Subject: A/55/19/PL

I live at Grey Tiles in Ham Manor Way opposite Ashurst and the ninth tee.

Section

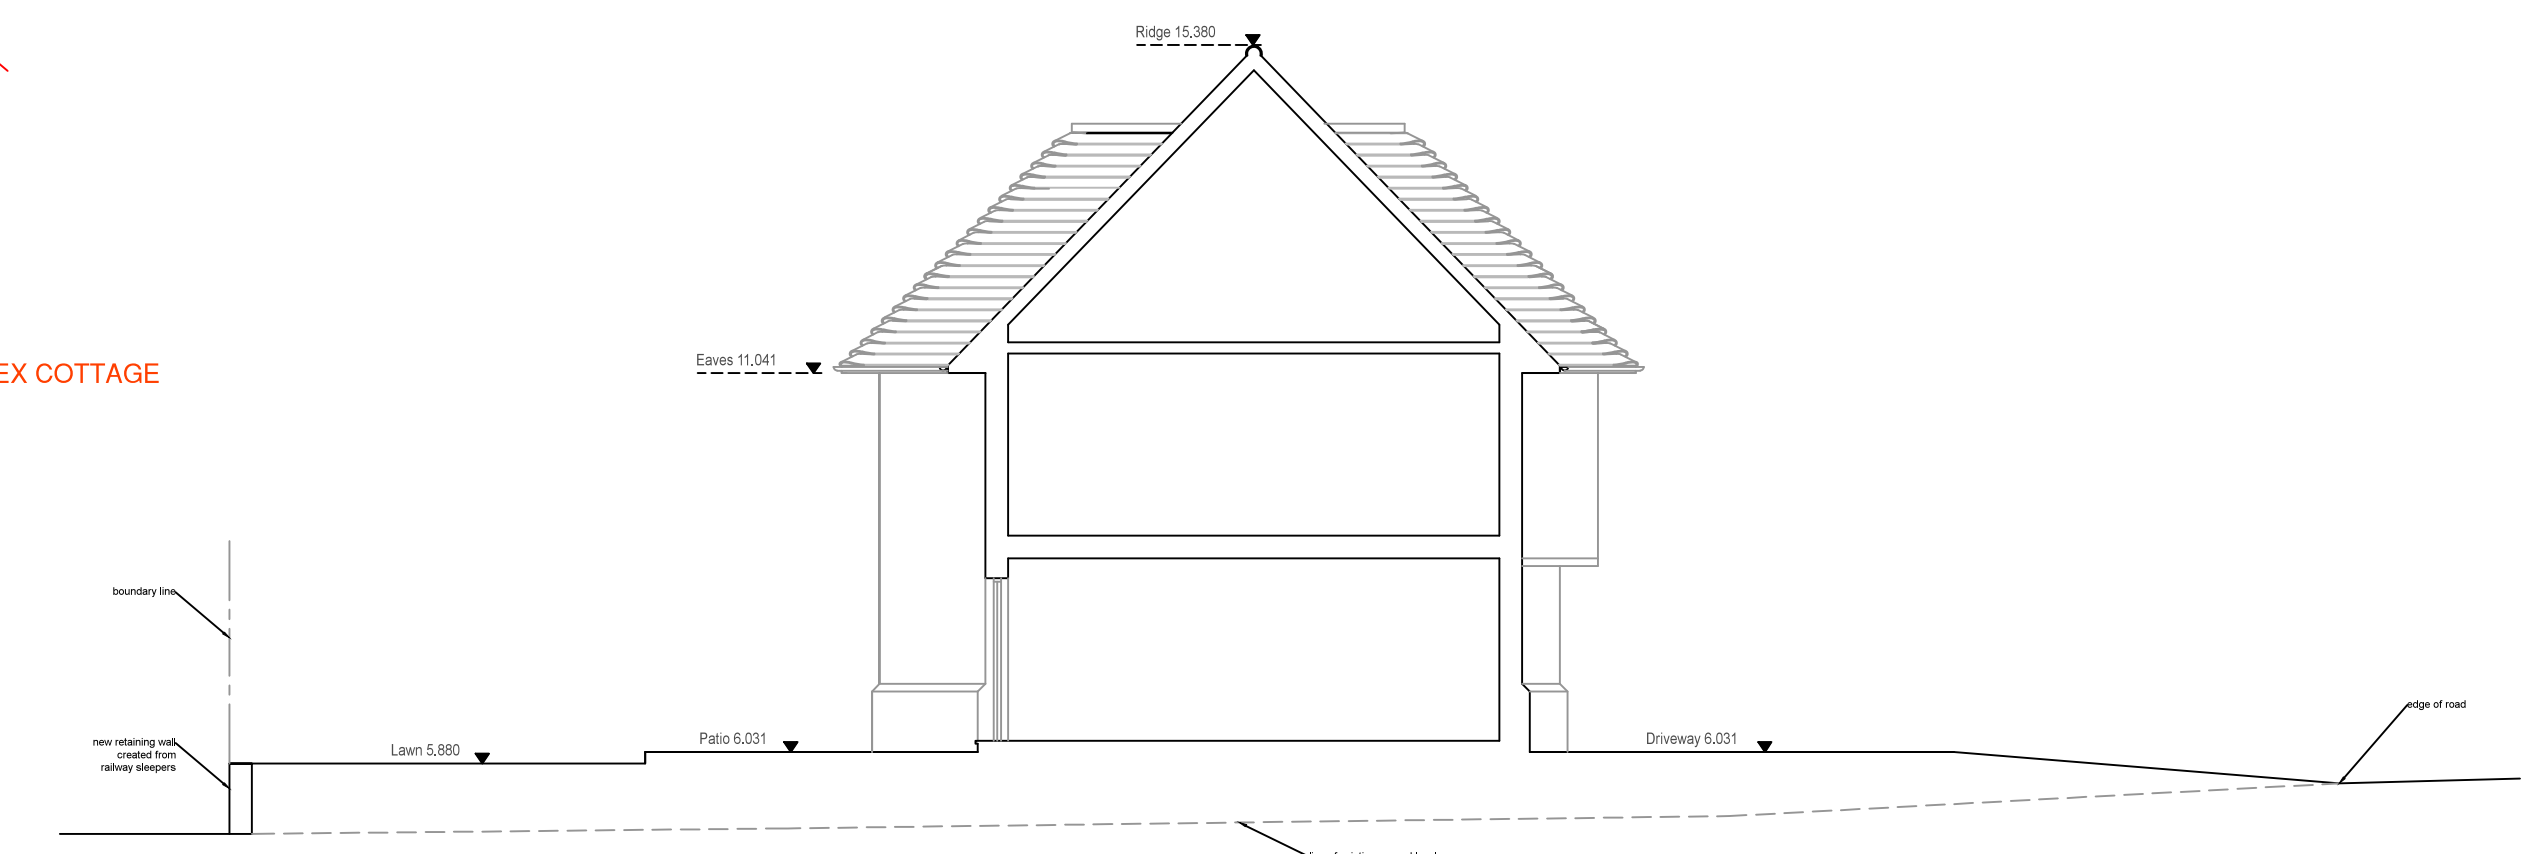
I am concerned over this new application as I don't think it has changed in size from the last application.

It is still far to big and will look enormous against the bungalows opposite.

We really do not want another property as big as Ashurst as it really overpowers my bungalow. Perhaps if a large bungalow was built that would be advantageous to everyone concerned.
